Project Name: Century Tire Plaza

Project Address: 195 Kennebec Str.

Project Name: Century Tire Plaza
Address: 195 Kennebec Street, Portland, ME
Project ID: 2015-027
CBL: 34-C-9
Applicant: Northland Enterprises, LLC
Planner: Nell Donaldson

On April 14, 2015, the Planning Authority approved with conditions a Level II site plan for the redevelopment of the Century Tire site at 195 Kennebec Street. The decision is based upon the application as submitted by Northland Enterprises, LLC and prepared by FST, Inc., with plan revisions dated April 1, 2015. The proposal was reviewed for conformance with the standards of the City of Portland's site plan ordinance, Article V of the land use code. It should be noted that the plans for the project's Marginal Way and Kennebec Street frontages were found to meet the guidelines of the Marginal Way Master Plan and the Somerset Street Extension Feasibility Study respectively, and that the provision of the sidewalk along the property's eastern boundary was found to meet the city's B-7 and site plan standards related to street connectivity and safe access for all site users. The Level II site plan is approved with the following waivers and conditions:

Prepared For:	Address City, State
Consultant:	Architect:
Project:	Century Tire
Revisions:	Scale: As indicated
Date: 05-01-2015	<b>BUILDING A ELEVATIONS</b>
<b>A2.01</b>

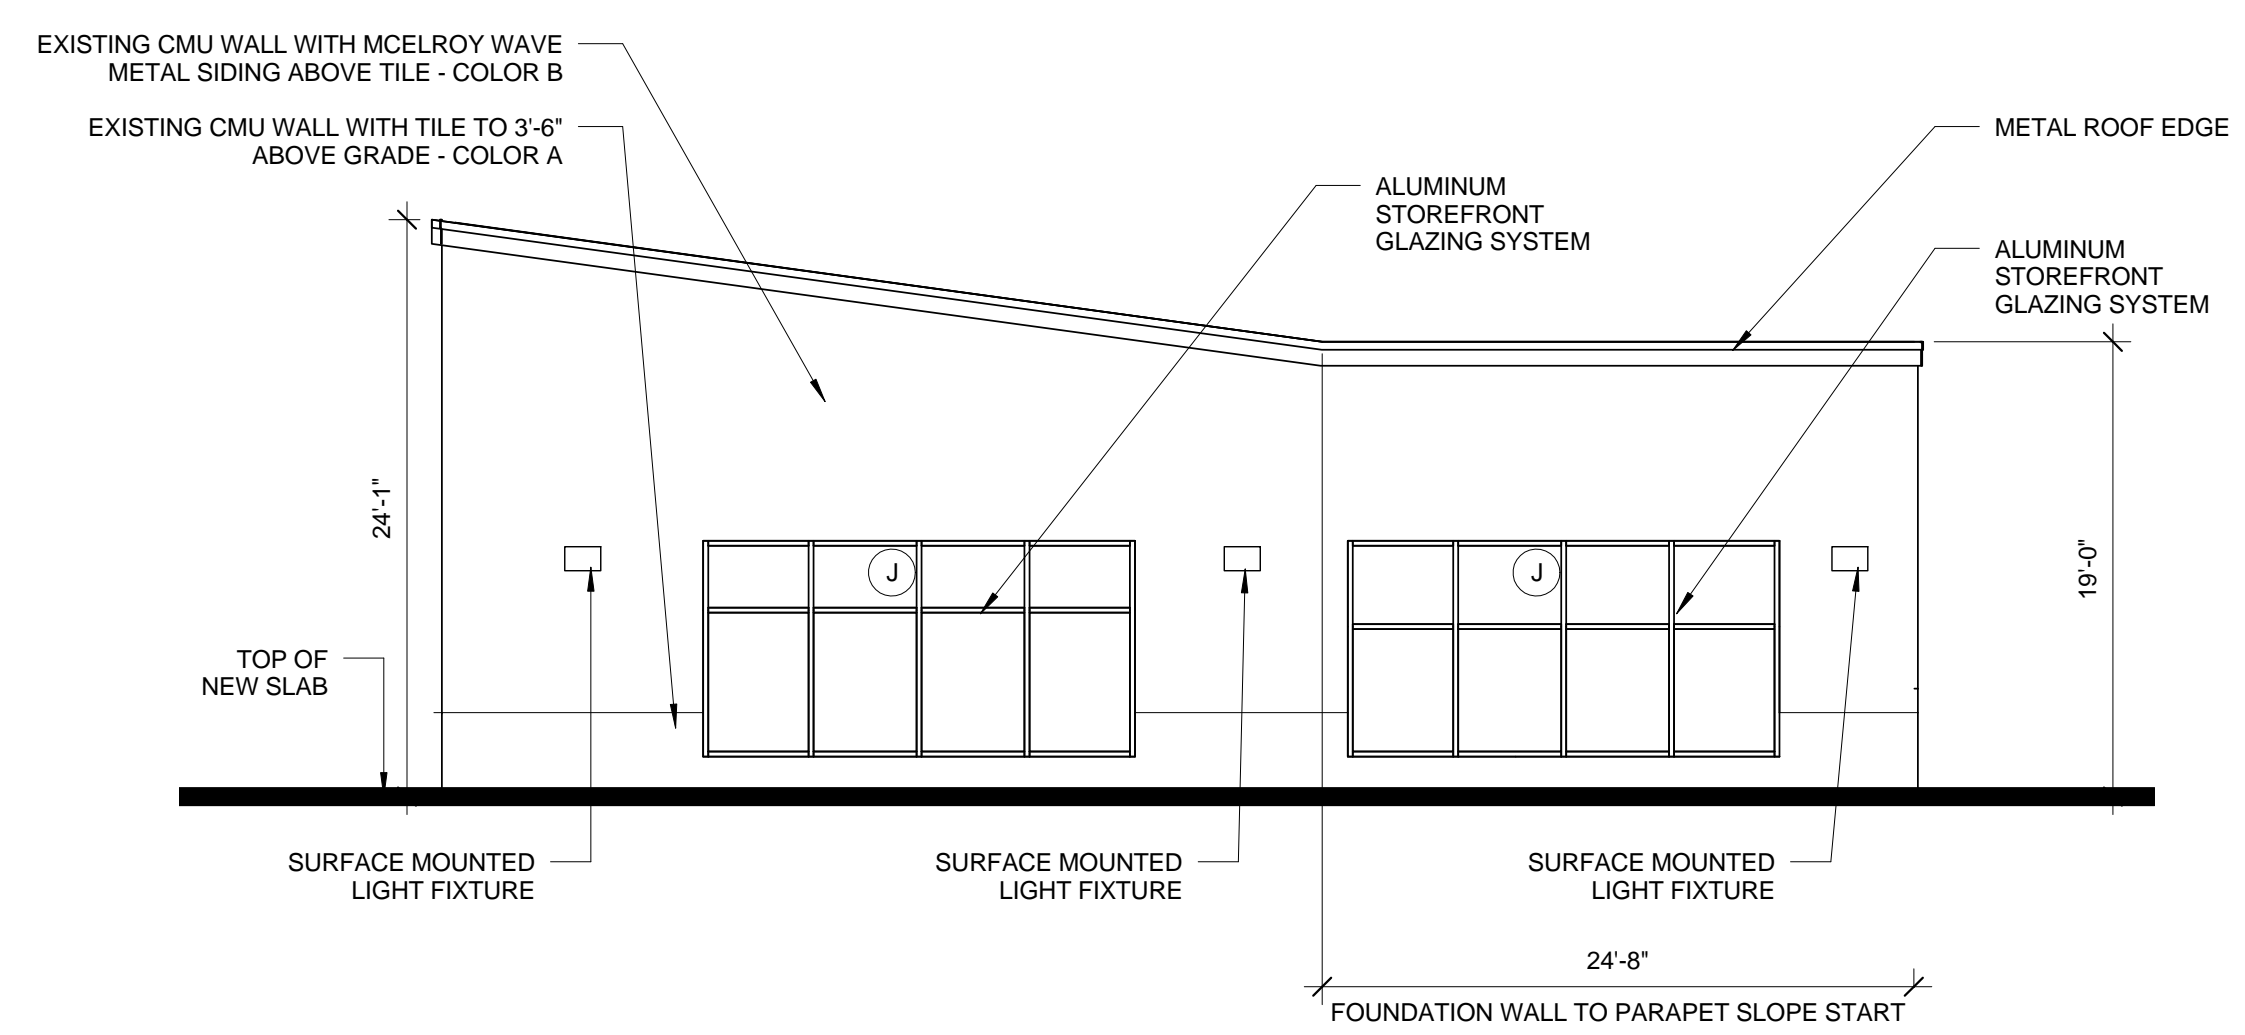
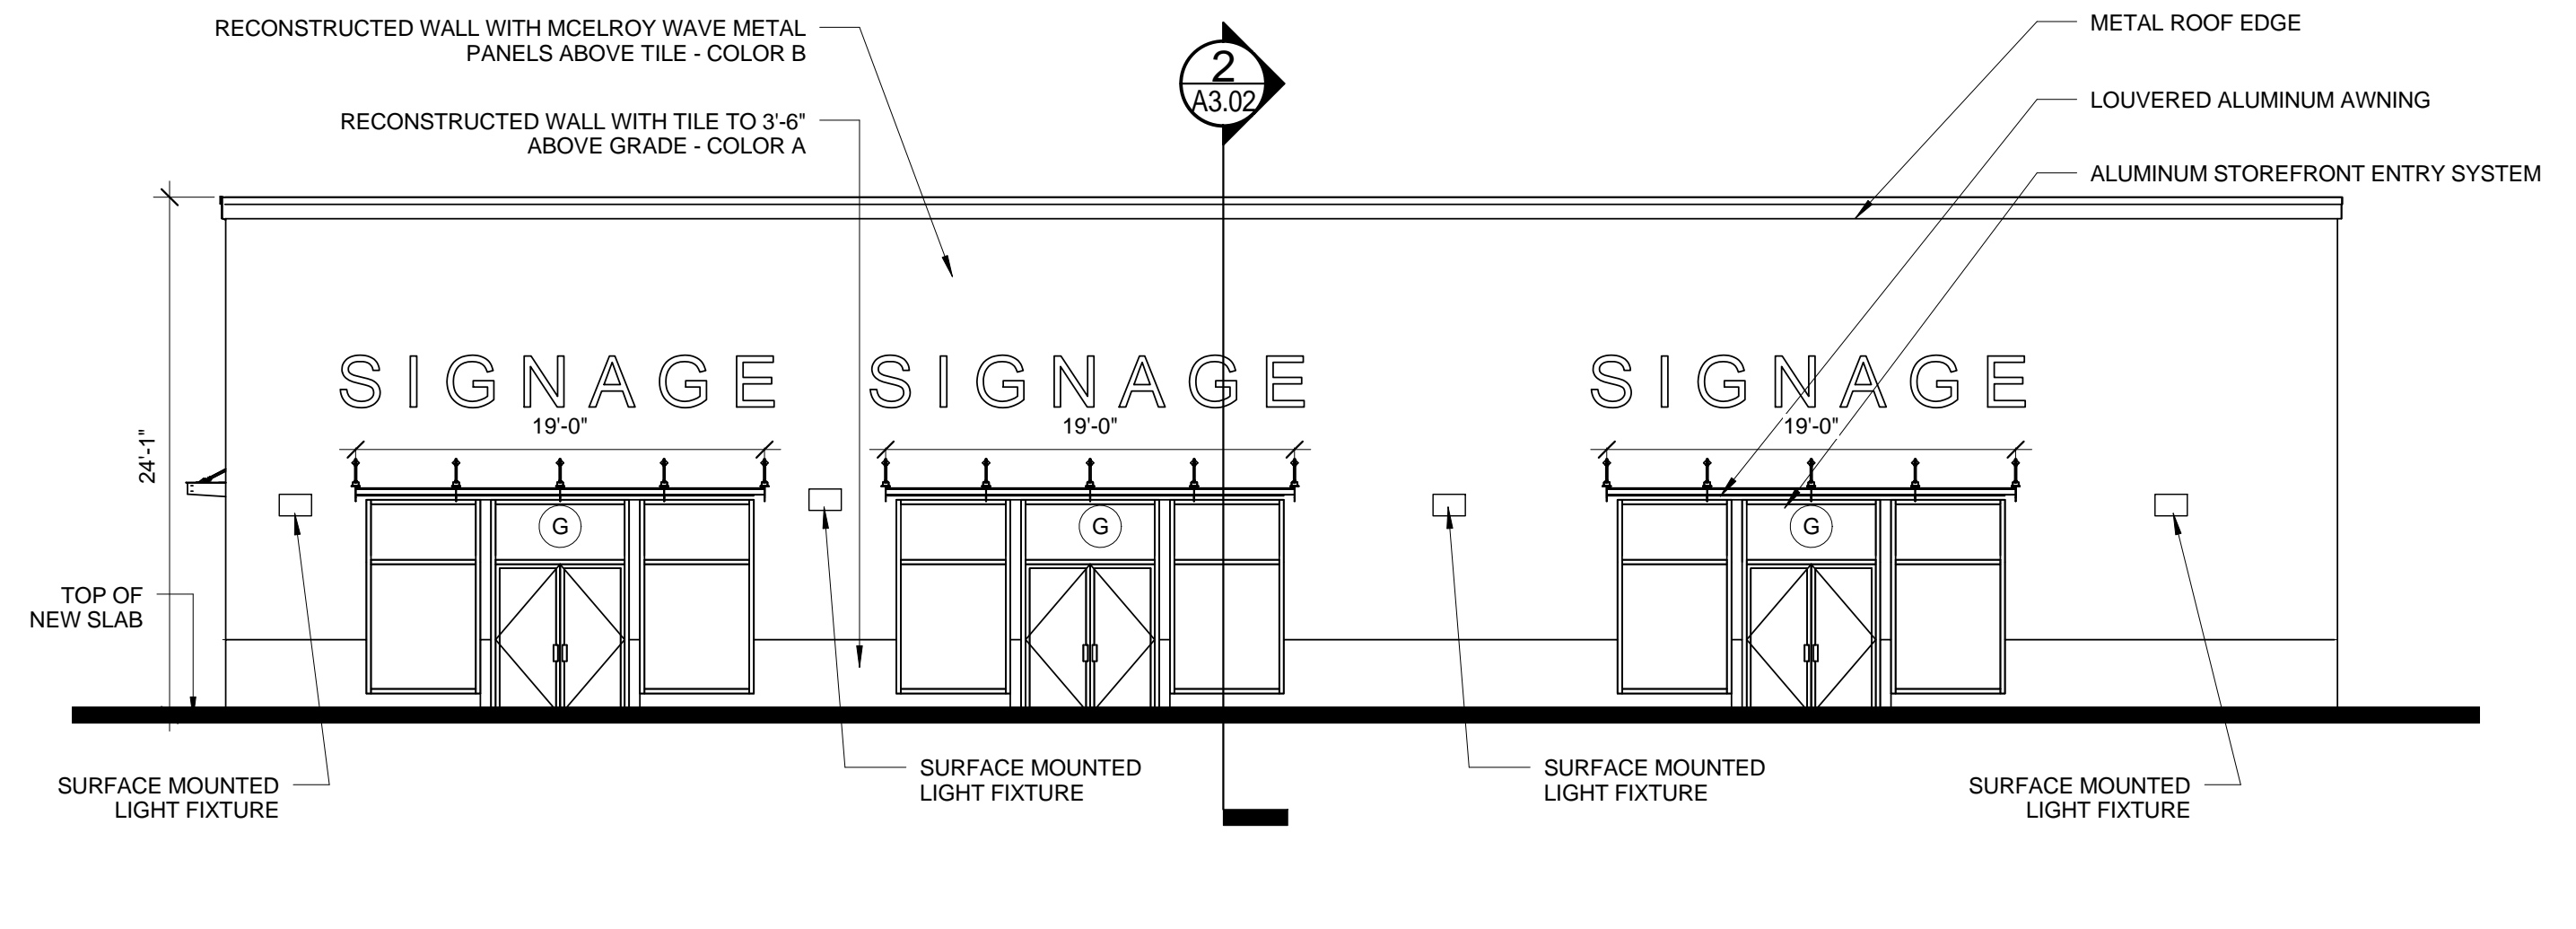
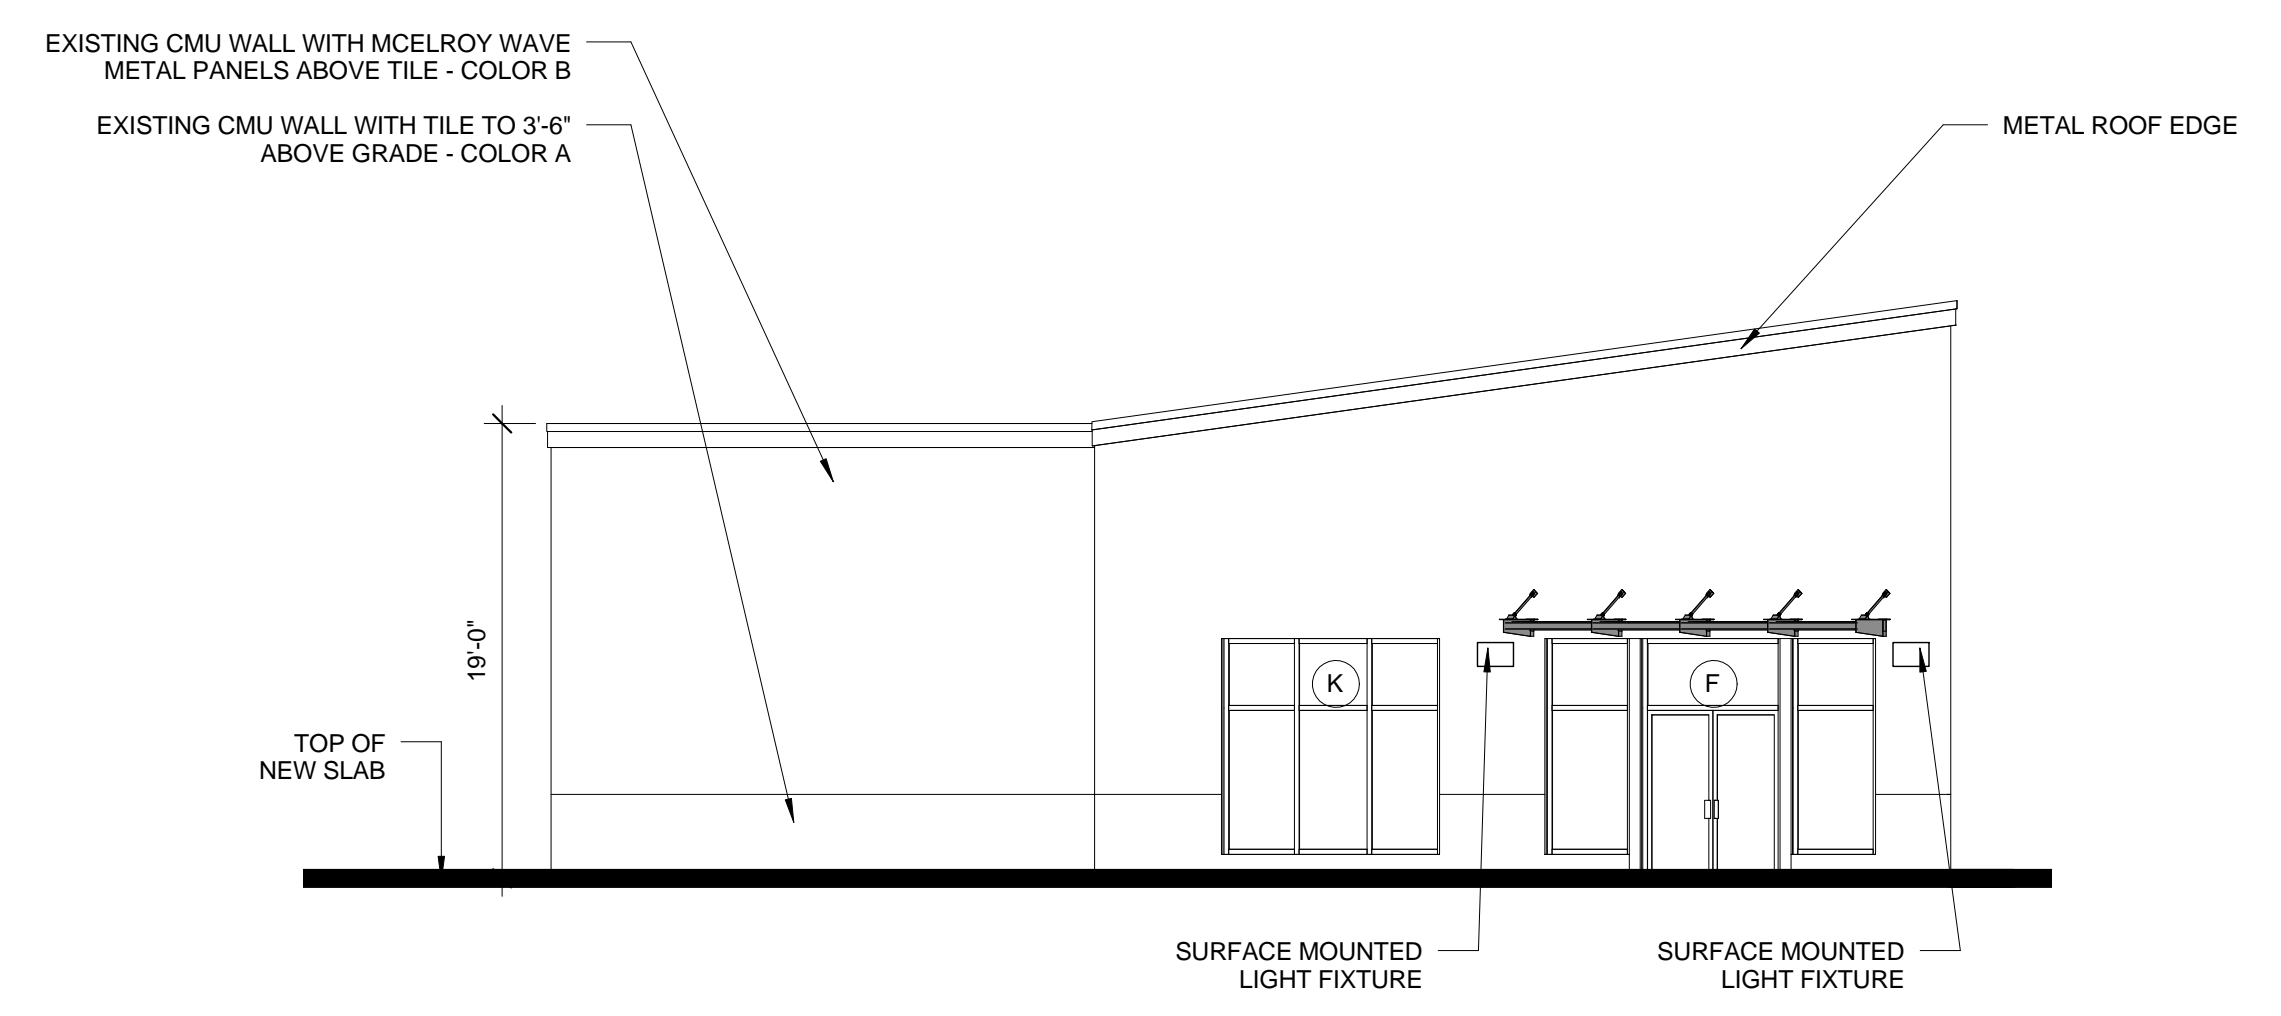
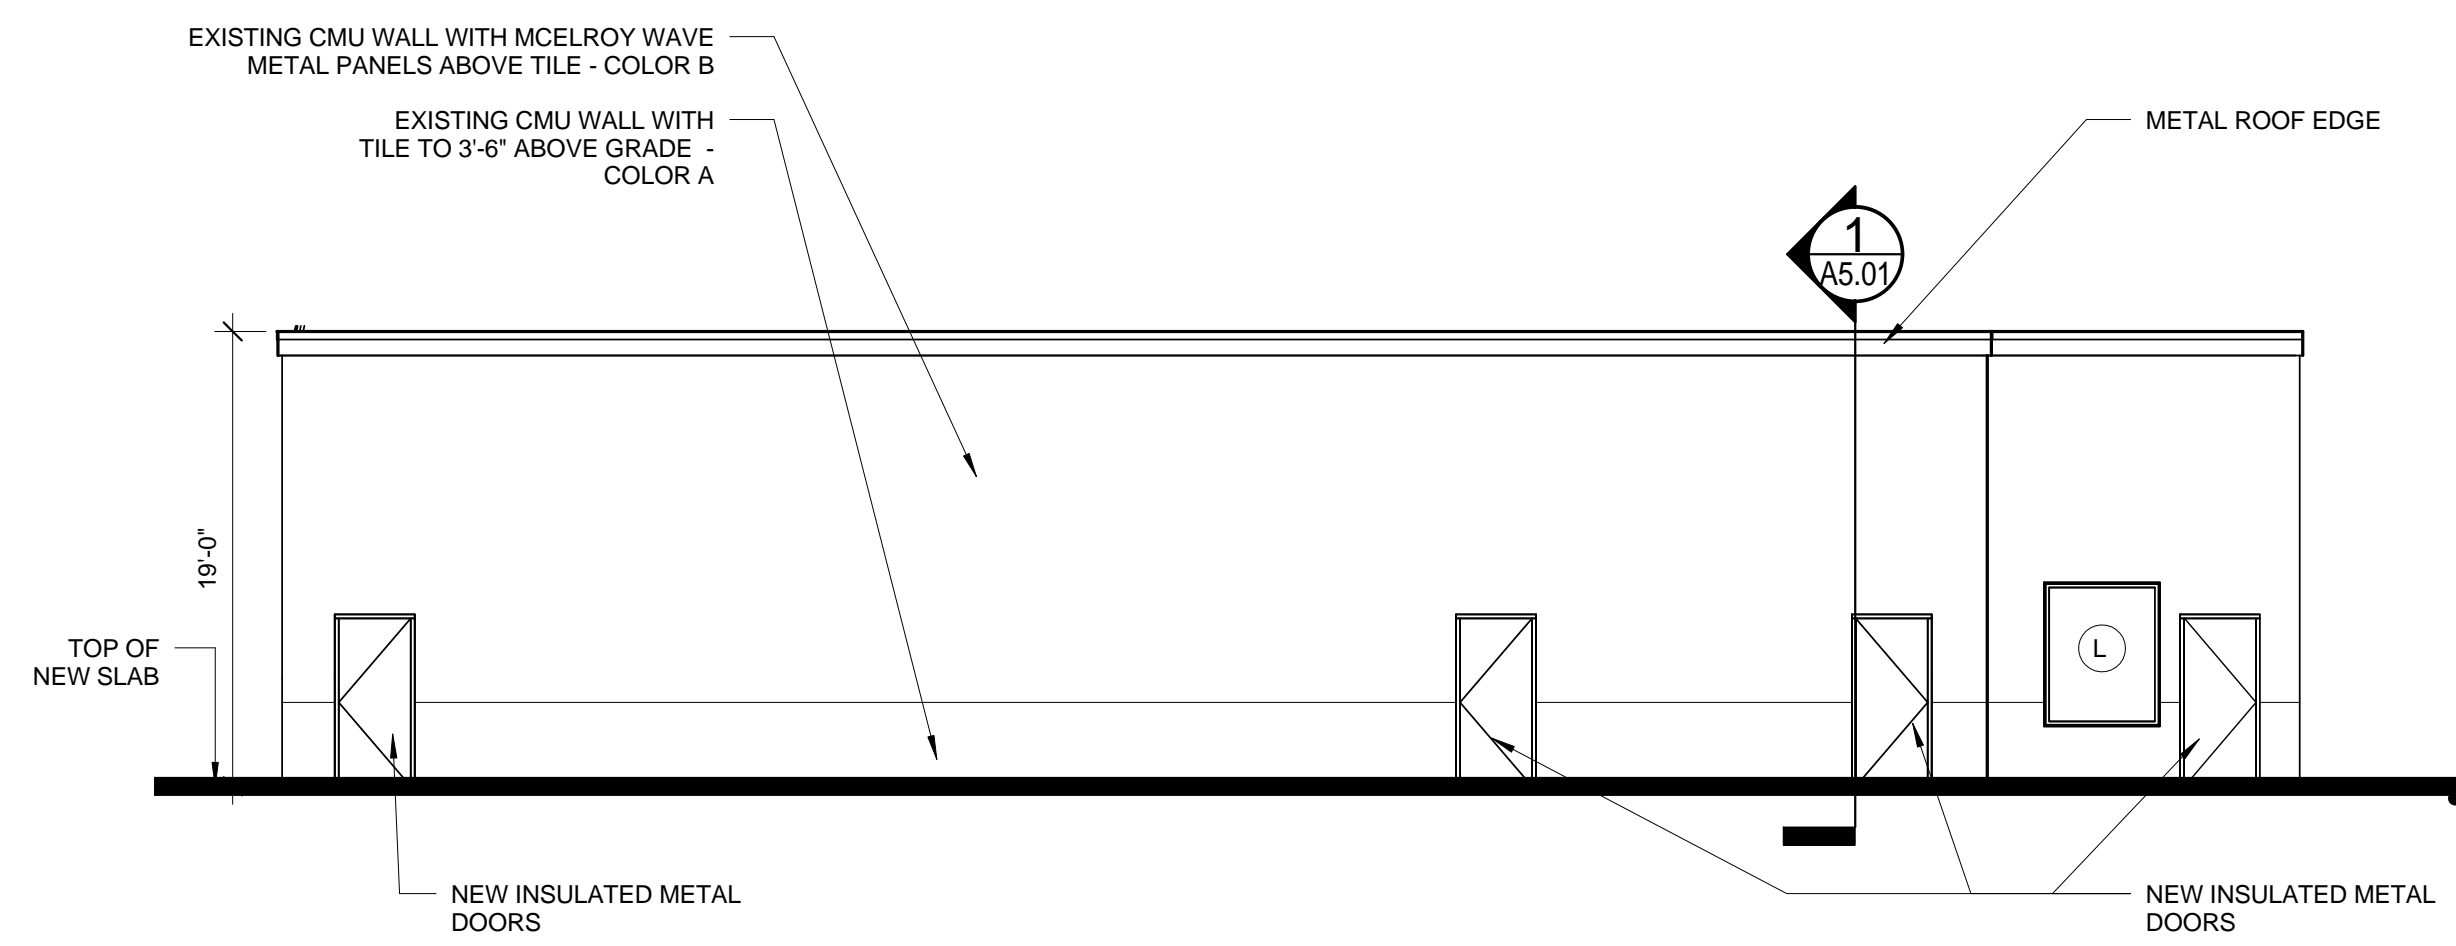
- **Building A** – The street-facing façade and entry should be given equal treatment to the other building entrances. In this case, that includes a sign, light, and canopy.

- **Building A** – The street-facing façade and entry should be given equal treatment to the other building entrances. In this case, that includes a sign, light, and canopy.

- done 5/5/15
10. The applicant shall provide revised elevations depicting the street-facing façade and entry of Building A with treatment similar to the other building entrances, including a sign, light, and canopy, for review and approval by the Planning Authority; and
